Consultation Response from KC, Conservation & Design

Application: 2025/91645 & 2025/91122

Address: Turnbridge Mills, Quay Street, Huddersfield, HD1 6QT

Proposals: REVISED/ADDITIONAL INFORMATION RECEIVED. Listed Building Consent for redevelopment of site for mixed-use E(g) (i, ii and iii) and B8 including: demolition of buildings and re-cladding of southern elevation of retained adjoining building; retention, conversion and renovation of existing mill/office/workshop/engine house building including alterations; erection of two new buildings; formation of two vehicular access points, service yard and parking areas; and other associated works.

Quay Street Elevation as Proposed

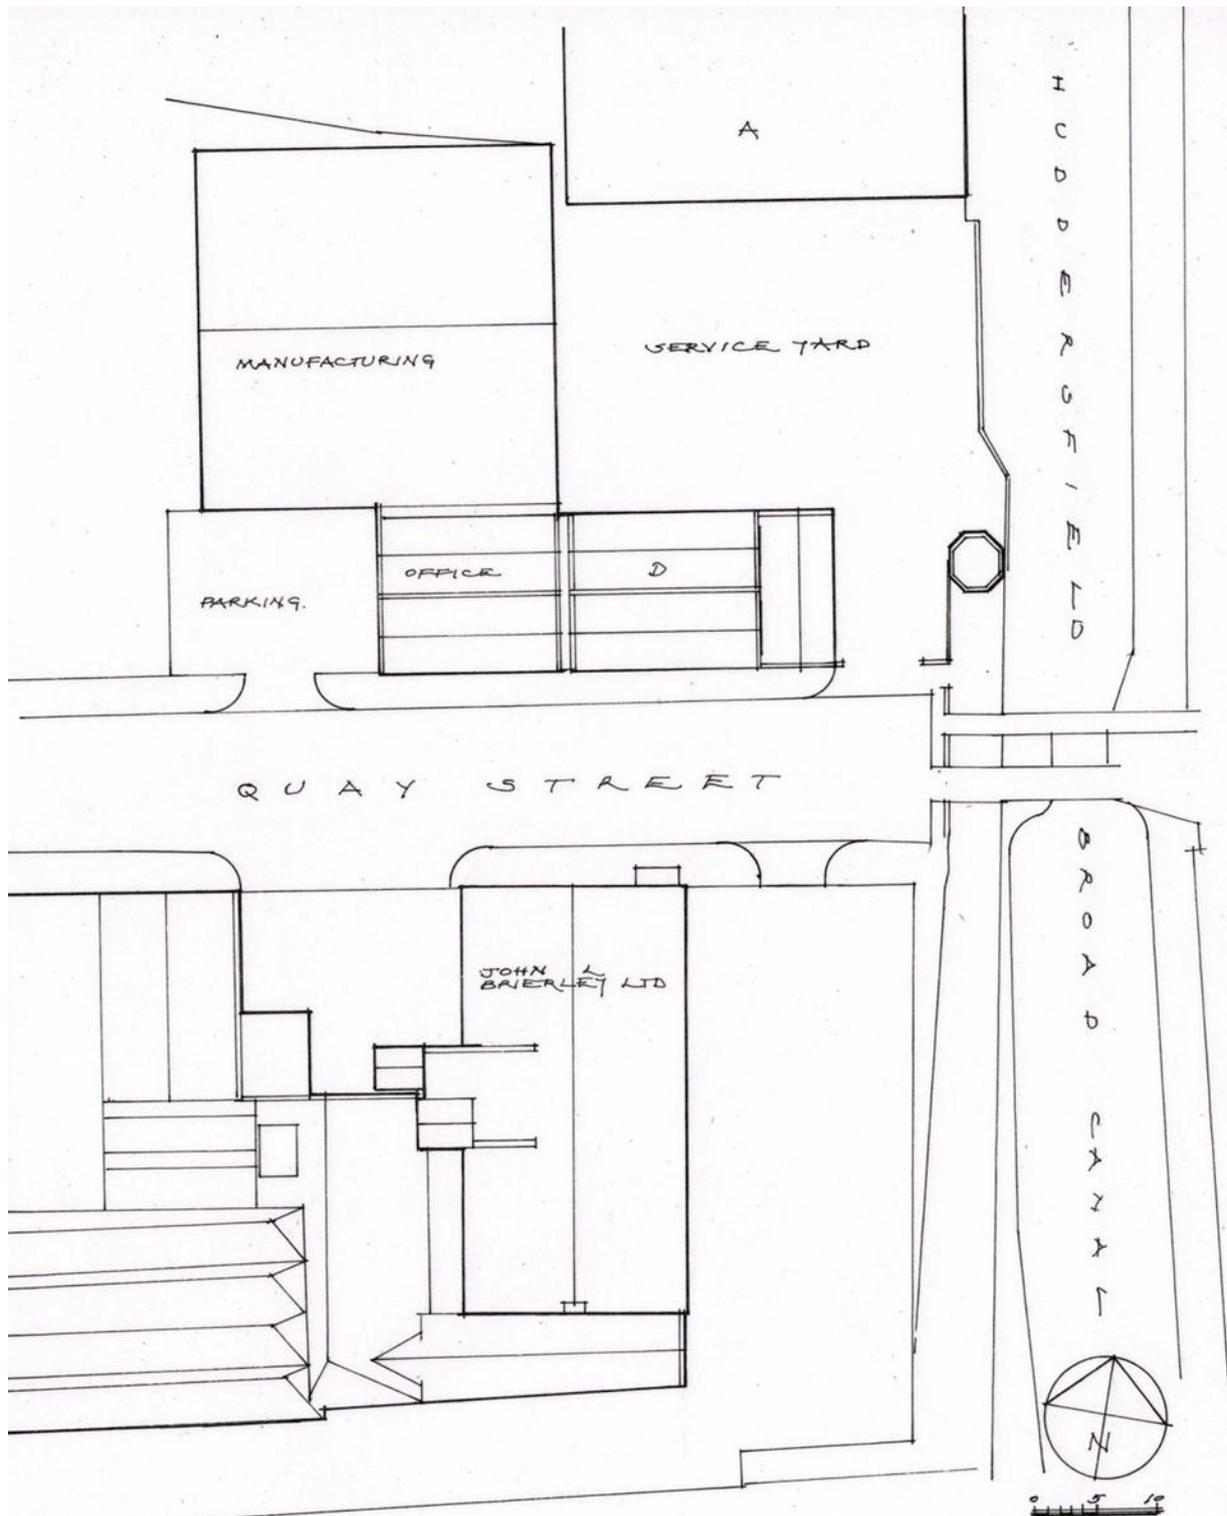
As Building D is being retained and significant investment is planned, it would be beneficial to standardize the window design across the building. All windows should ideally be wooden or aluminium with a six-pane configuration to ensure consistency.

*Canal Elevation as Proposed*

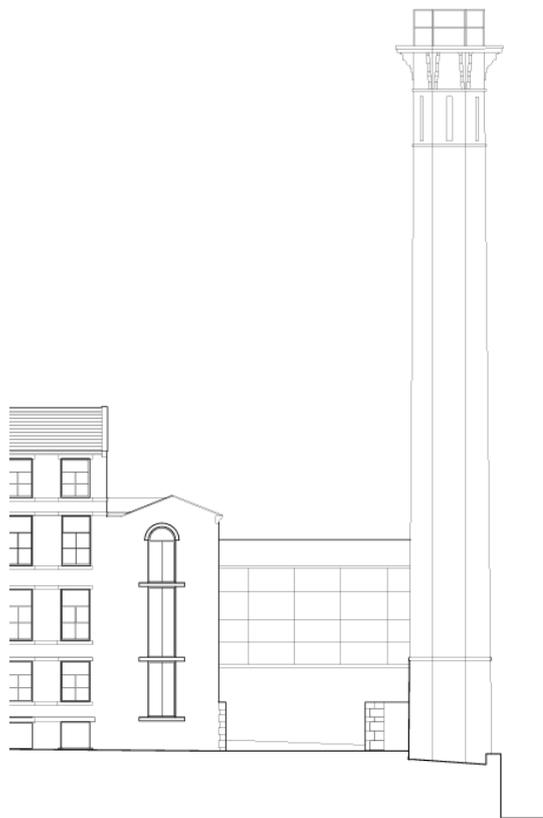
The reuse of the boundary wall from Building B is welcomed as it retains an element of the site's historic character. However, the area where Mill Building B once stood, adjacent to the proposed service yard, presents an opportunity for a high-quality landscape design. This should incorporate high quality materials and lighting that reflect the site's industrial heritage, while softening the hard edge of the service yard. Interpretation boards would be beneficial to explain the history of the site and illustrate its evolution, ensuring the loss of Mill B is recorded and understood by the public. Good examples of landscaping can be found at similar mills in the area like Sunny Bank Mills and Saltaire Mill.
